City of Albuquerque

April 3, 1979

Re: Master Storm Water Conveyance Study
- Academy/Tramway/Eubank Sector Development Plan

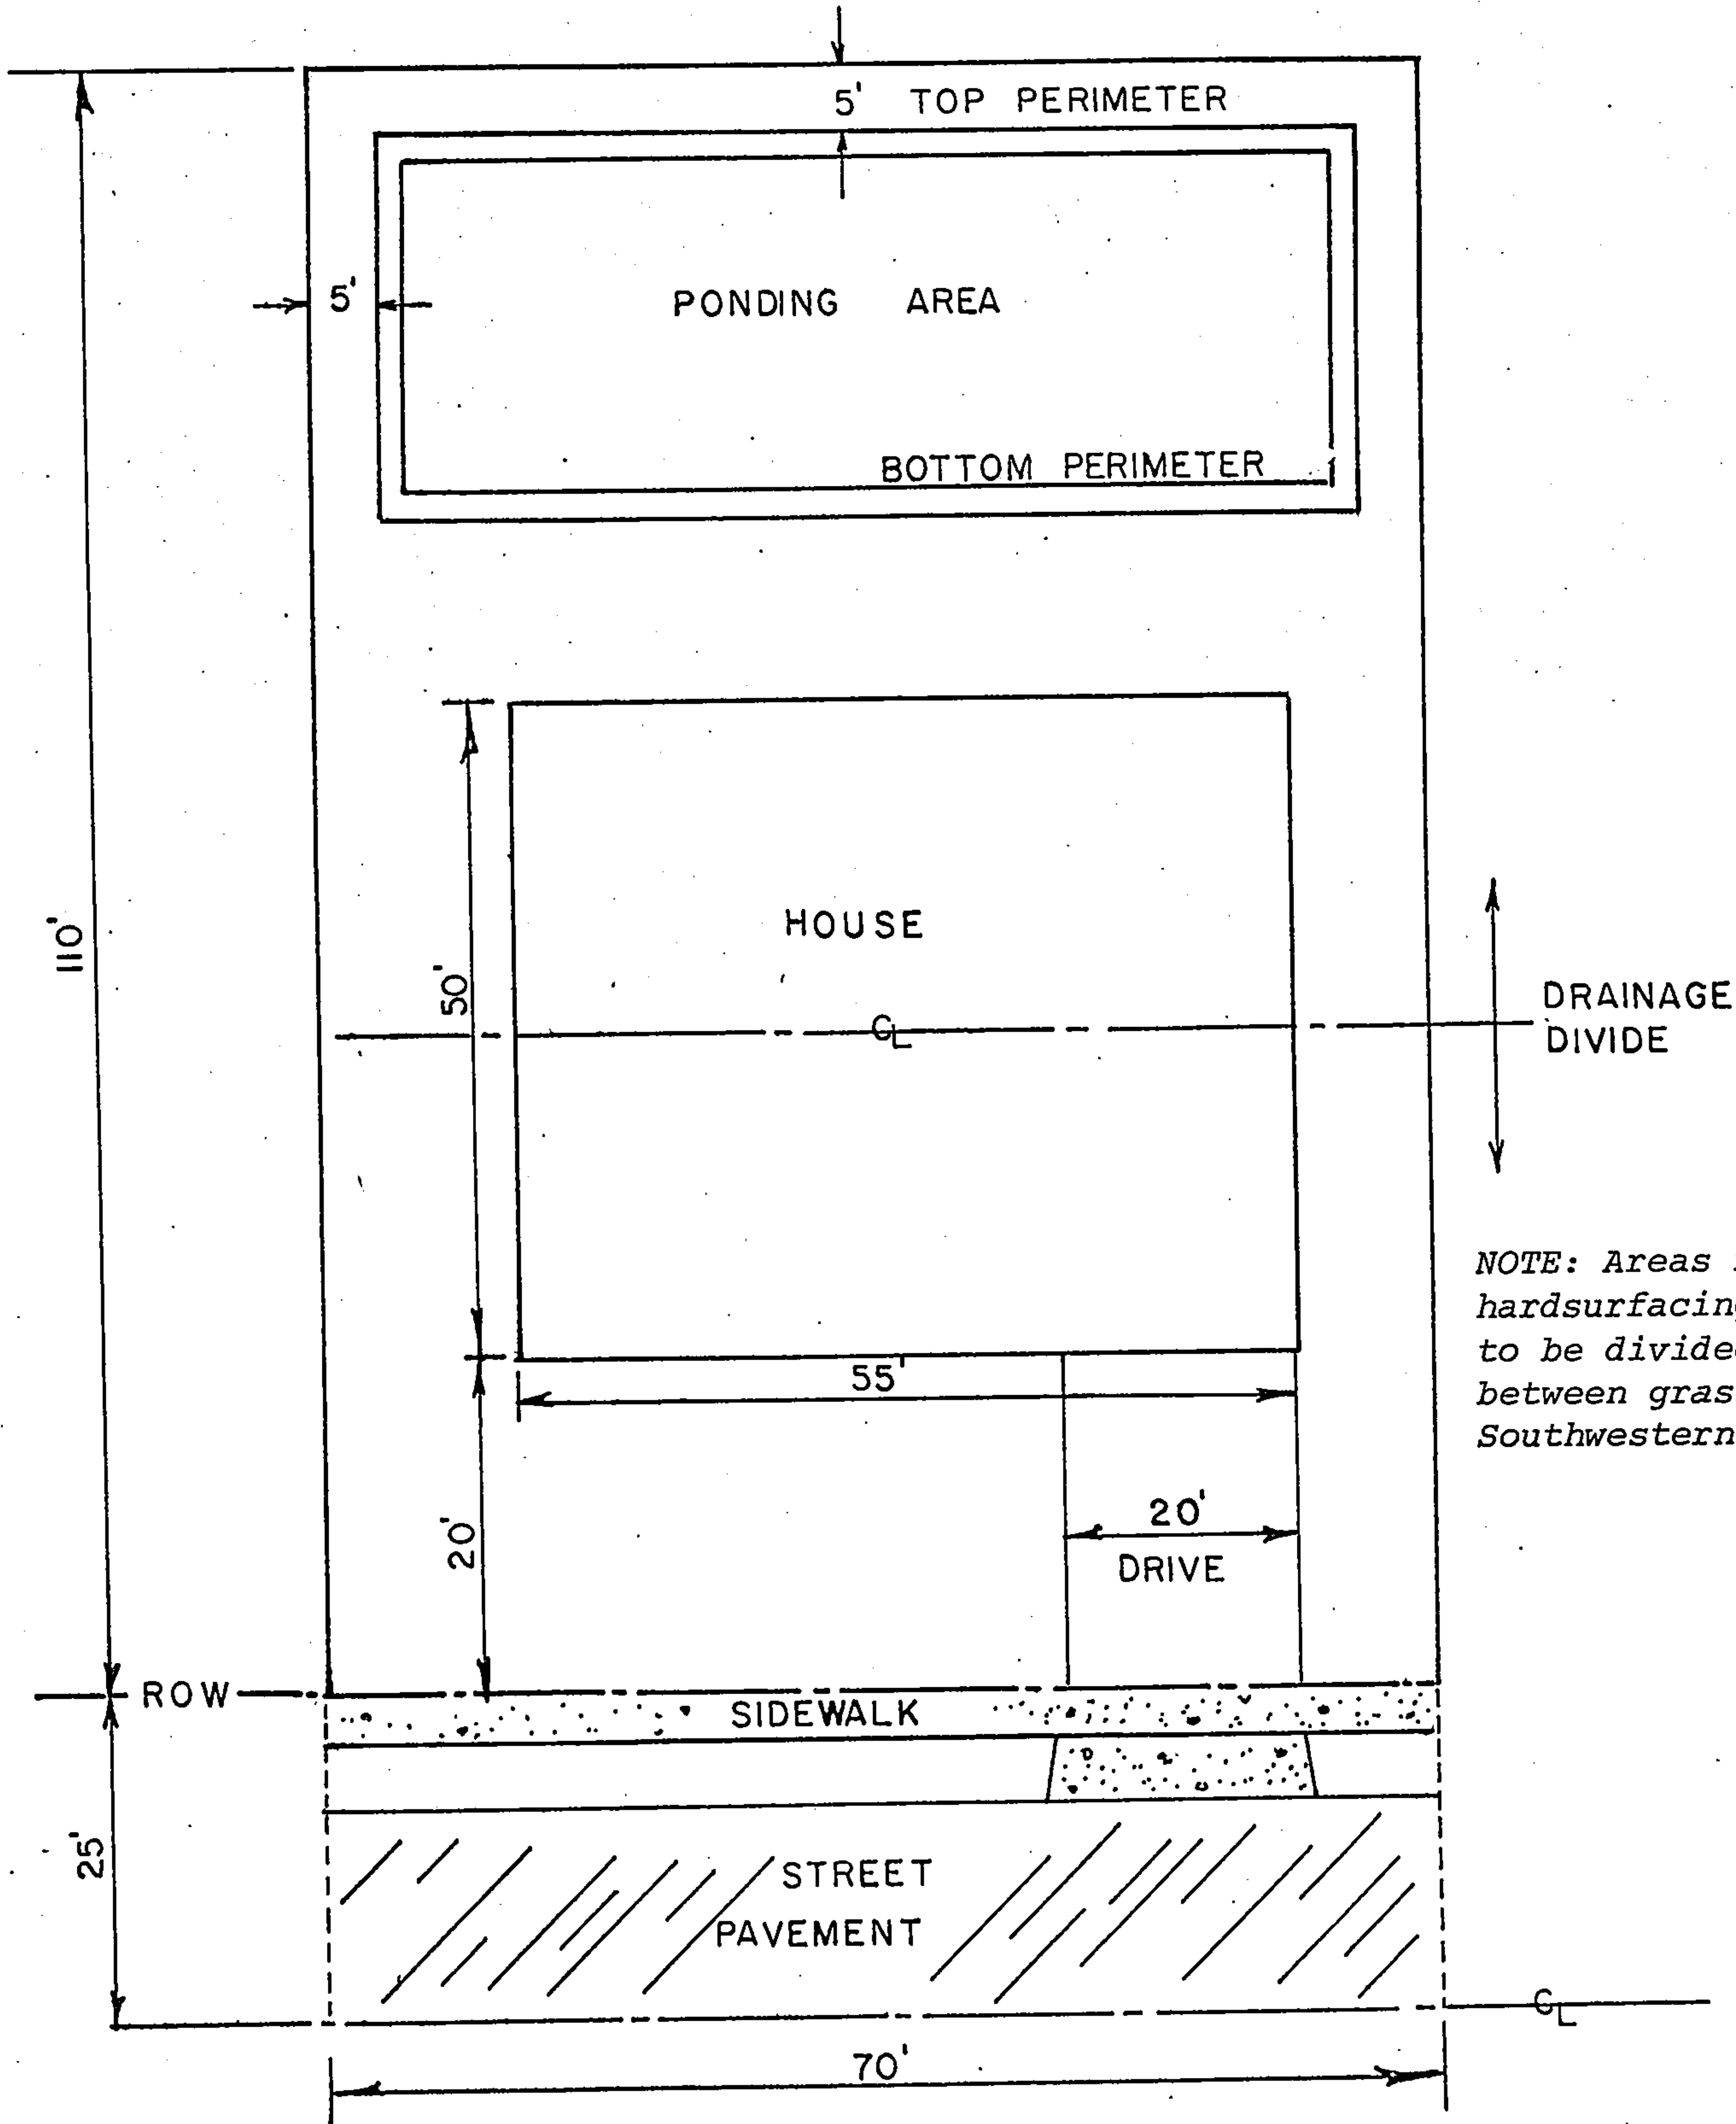
The conveyance study covered the area quite well. Only one comment. The energy dissipator east of Eubank Blvd. at C7, should be moved across Eubank Blvd. and an all-weather crossing at Eubank Blvd. be provided.

The alternates covered on page nine of the subject report do not provide for the controlled flow of water discharged into Academy Road or Eubank Blvd. The use of a one-foot curb to control flow indicates a very large water problem that must be solved prior to the flow reaching Eubank Blvd., as the flow will be too great to turn effectively.

The 10-year flows must be picked up in a storm drain prior to reaching Eubank Blvd. and then discharged into the appropriate arroyo. The excess flow may then be controlled in the streets.

# PLATE 4

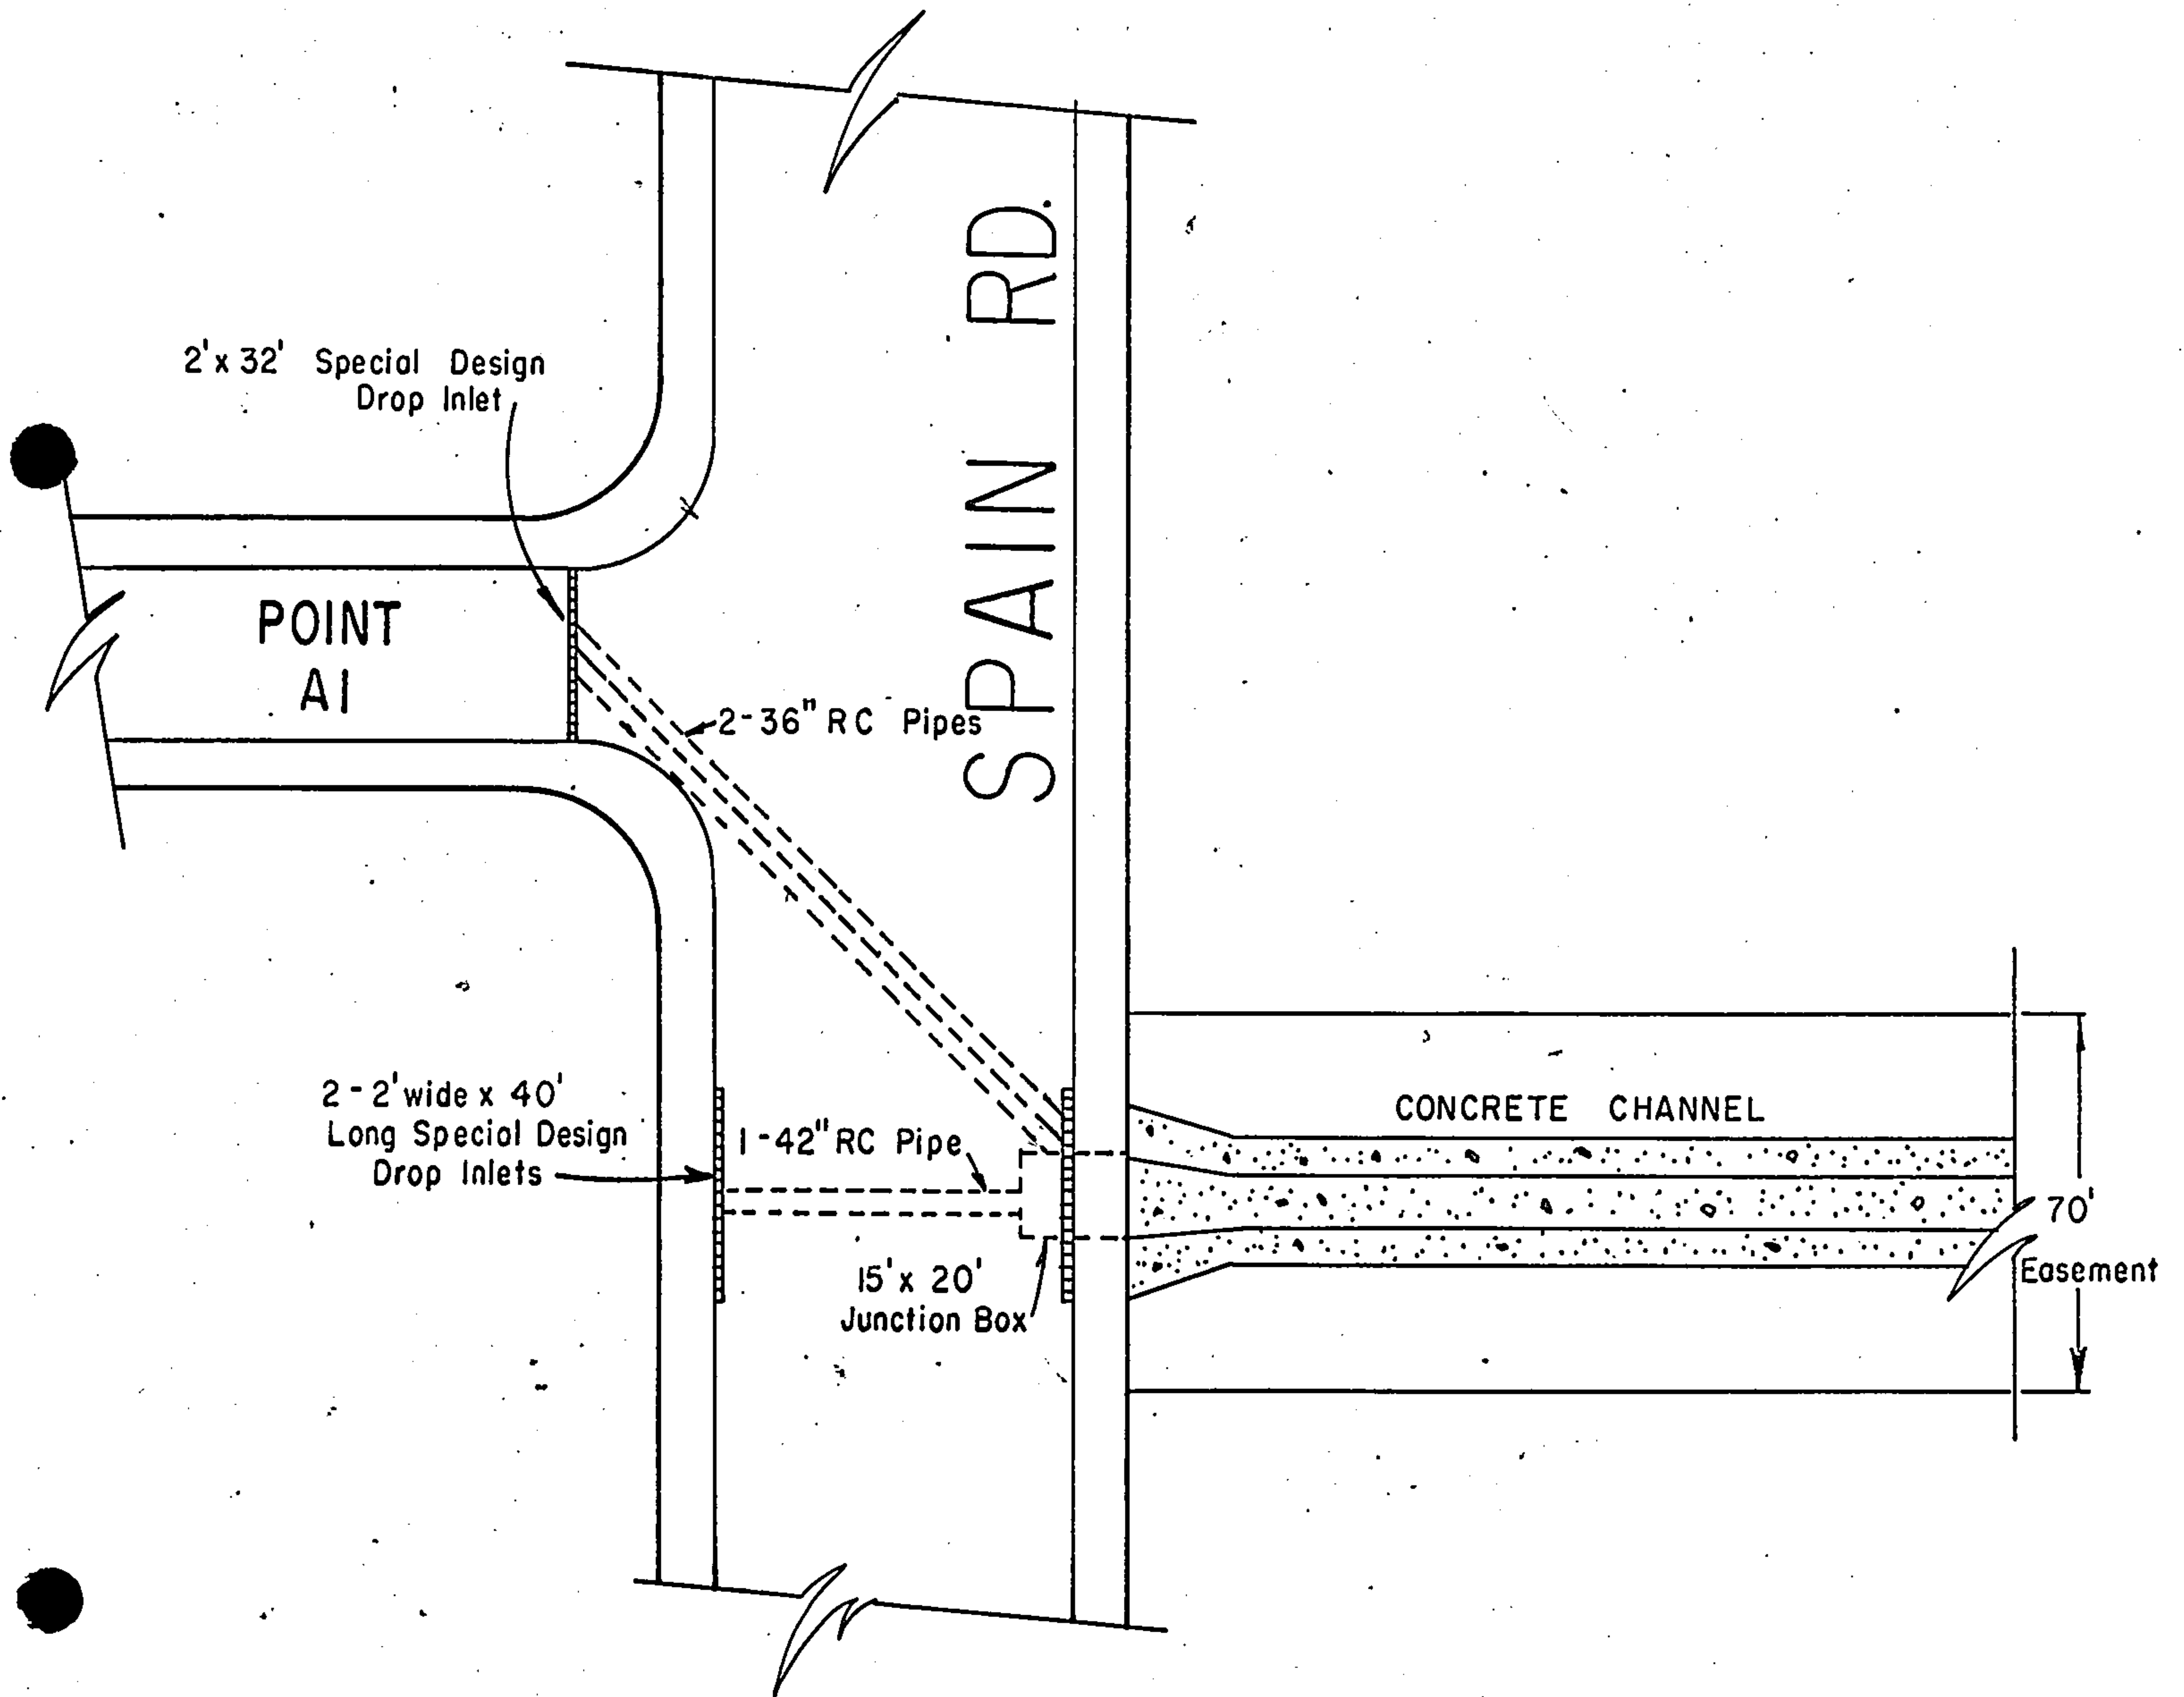
Due to the quantity and velocity of the waters generated within AREA "B", it is required that the 10-year flows be conveyed from Point B-2 in a pipe through AREA "G" and discharged behind the Juan Tabo Dam. The difference between the 10-year and 100-year flows will then utilize the street patterns both down Spain Road and through AREA "G". A split of flows would create a much safer flow pattern than diverting all the flows down Spain Road.

At location A-1 the flows from the subdivision north of Spain Road should be collected along with the overflow from AREA "B" in Spain Road, and channeled behind the Juan Tabo Dam as outlined in your report.
